**KIRKLEES METROPOLITAN COUNCIL  
INVESTMENT & REGENERATION SERVICE**

**DELEGATED DECISION TO DETERMINE PLANNING APPLICATIONS**

| Reference No:         | <b>2025/62/91639/W</b>                                                       |
| Description:          | Erection of 3 storey extension and alterations to form student accommodation |

Drawing No. 004 PP-1004

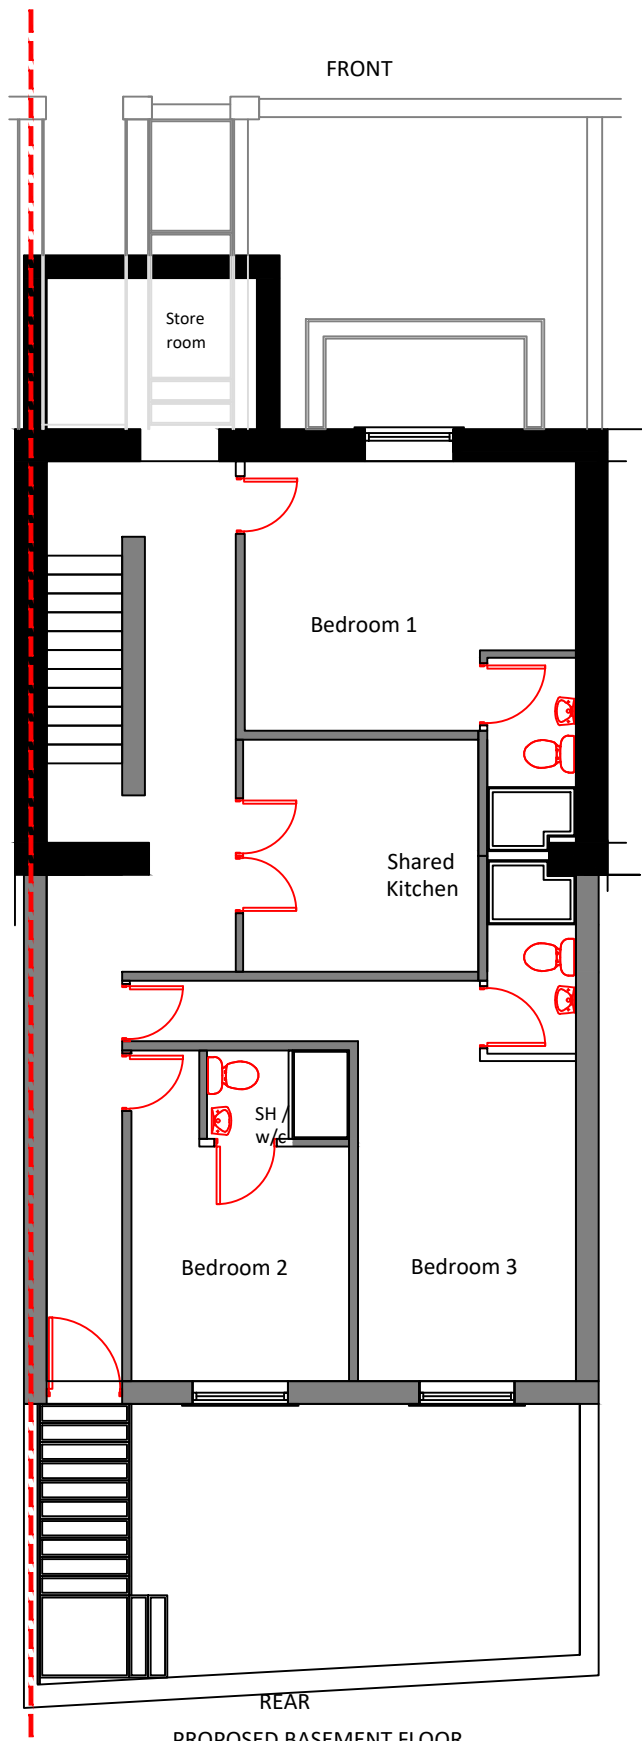
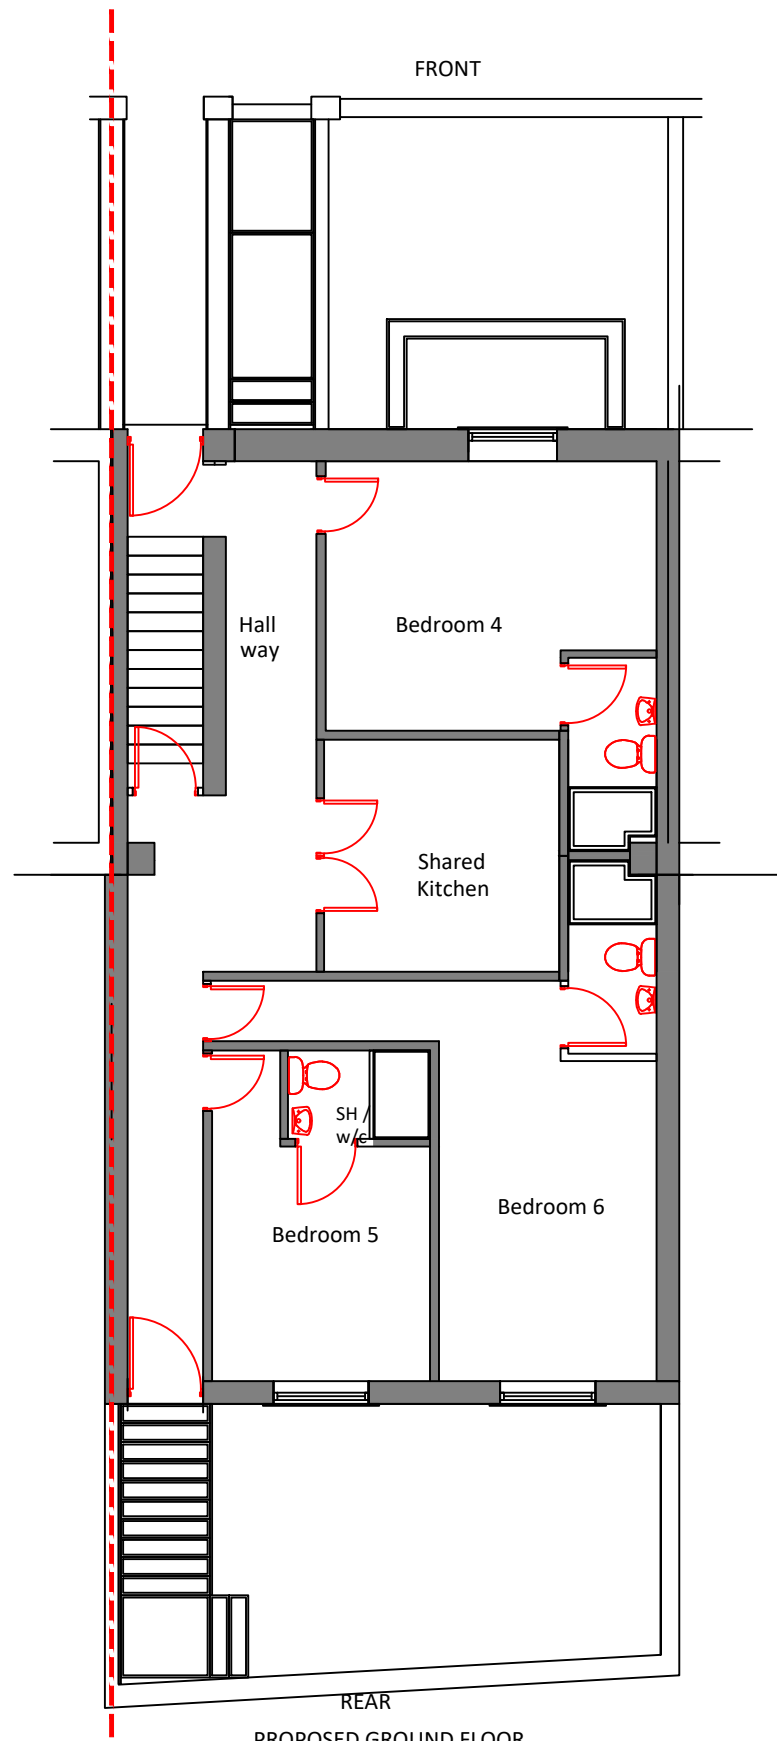
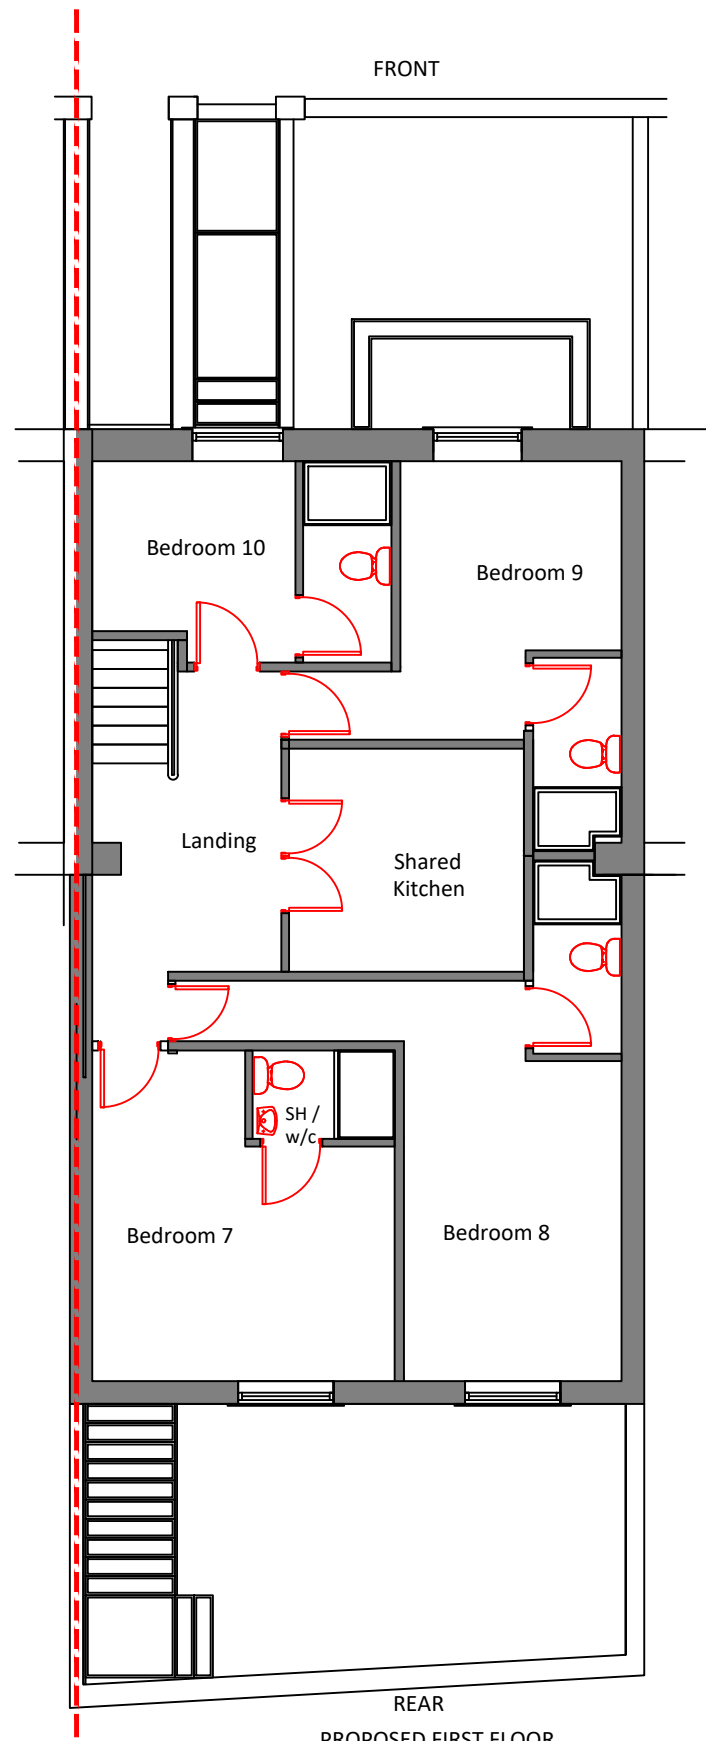
The proposed three storey extension would project approximately 7m from the rear elevation of the property. The enlargement would have an overall height of approx. 9.2m and an eaves height of approx. 8.4m. The extension would be faced in natural stone and would incorporate a mono-pitched roof finished in Grey slate to match the appearance of the host property. Although the enlargement would feature a lower ridge line, due to its design, scale and massing, the extension would lack subservience to the original dwelling and would be an incongruous addition. Furthermore, the extension would alter the scale and form of the original build and would fail to integrate with the host dwelling. On this basis, it is considered that the proposal would unduly harm the character and appearance of the host property and surrounding area and cannot be supported in terms of visual amenity.

42 Bradford Road is a residential property located north of the application site. The submitted plans confirm that the proposed three storey rear extension would extend beyond the rear elevation of no.42 by approximately 2.5m and would fail to comply with the 45 degree rule in relation to the neighbour's rear fenestration. Therefore, it is considered that the proposal would result in an overbearing and overshadowing form of development due to its scale, siting and design. As such, the harm caused to this neighbour would be detrimental and cannot be supported in terms of residential amenity.

no.17a and approx. 12.2m to the rear elevation of no.19. It is considered that the separation distances between habitable rooms would be insufficient and the proposal would therefore give rise to an unacceptable overlooking relationship. As such, the harm caused to these neighbours would be significant and cannot be supported in terms of residential amenity.

38 Bradford Road is the adjoining property located south of the application site. The submitted plans demonstrate that the proposed three storey rear extension would surpass the rear elevation of no.38 by approximately 2.3m and would fail to accord with the 45 degree rule in relation to the neighbour's rear fenestration. Therefore, it is considered that the proposed development would have an overbearing and overshadowing impact due to its scale, siting and design. As such, the harm caused to this neighbour would be detrimental and cannot be supported in terms of residential amenity.

The site is within Flood Zone 2 and within 20m of the culverted Grimescar Dike. Kirklees Council Flood Mapping indicates that surface water flooding to a depth of 0.9 to 1.2m for a 1 in 100 year rainfall event is possible. It is noted that the proposed basement arrangement shown on the Proposed Floor Plans drawing indicates that the basement floor level will be converted into 3 bedrooms and a shared kitchen. Although there is a means to escape to the upper floors in the event of flooding, there is a serious risk that residents could be asleep and unaware of the potential danger. Therefore, officers considers that the risk to life for residents occupying the basement level bedrooms is unacceptable.

Waste Principle 19 of the Housebuilders Design Guide SPD outlines how provision for waste storage and recycling should be incorporated into the design of new developments. The application relates to 10 apartments. The development is entitled to 2 x grey 240ltr bins and 1 x green 240ltr bin. It is not clear from the plans where these bins are going to be stored on site. As

PROPOSED REAR ELEVATION
SCALE 1:100 AT A3.

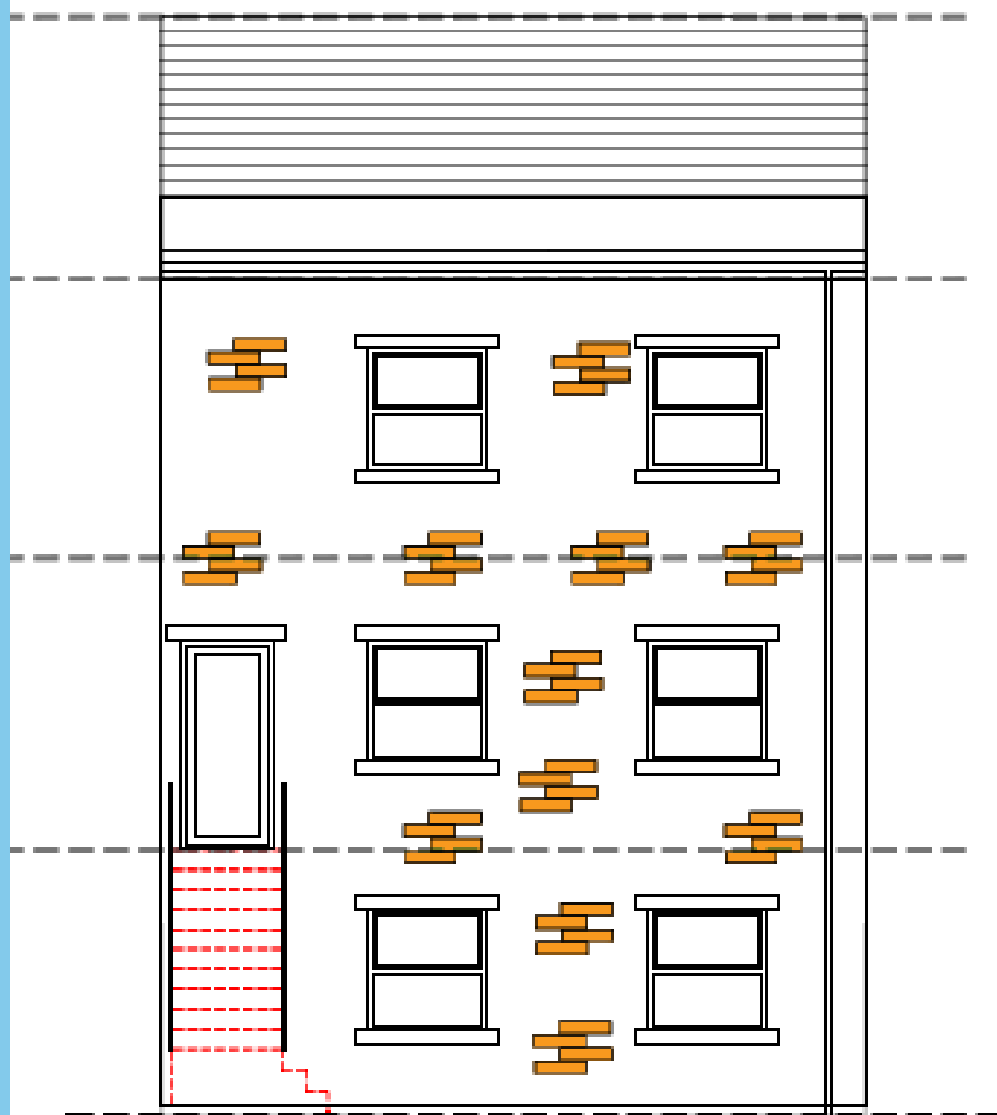
An external staircase would be erected to the rear elevation of the proposed three storey extension to provide access to the rear yard. The staircase would project approximately 4.1m and would have an overall height of approx. 2.8m. However, given its siting, the staircase is not considered to have any significant visual impact on the character and appearance of the street scene.
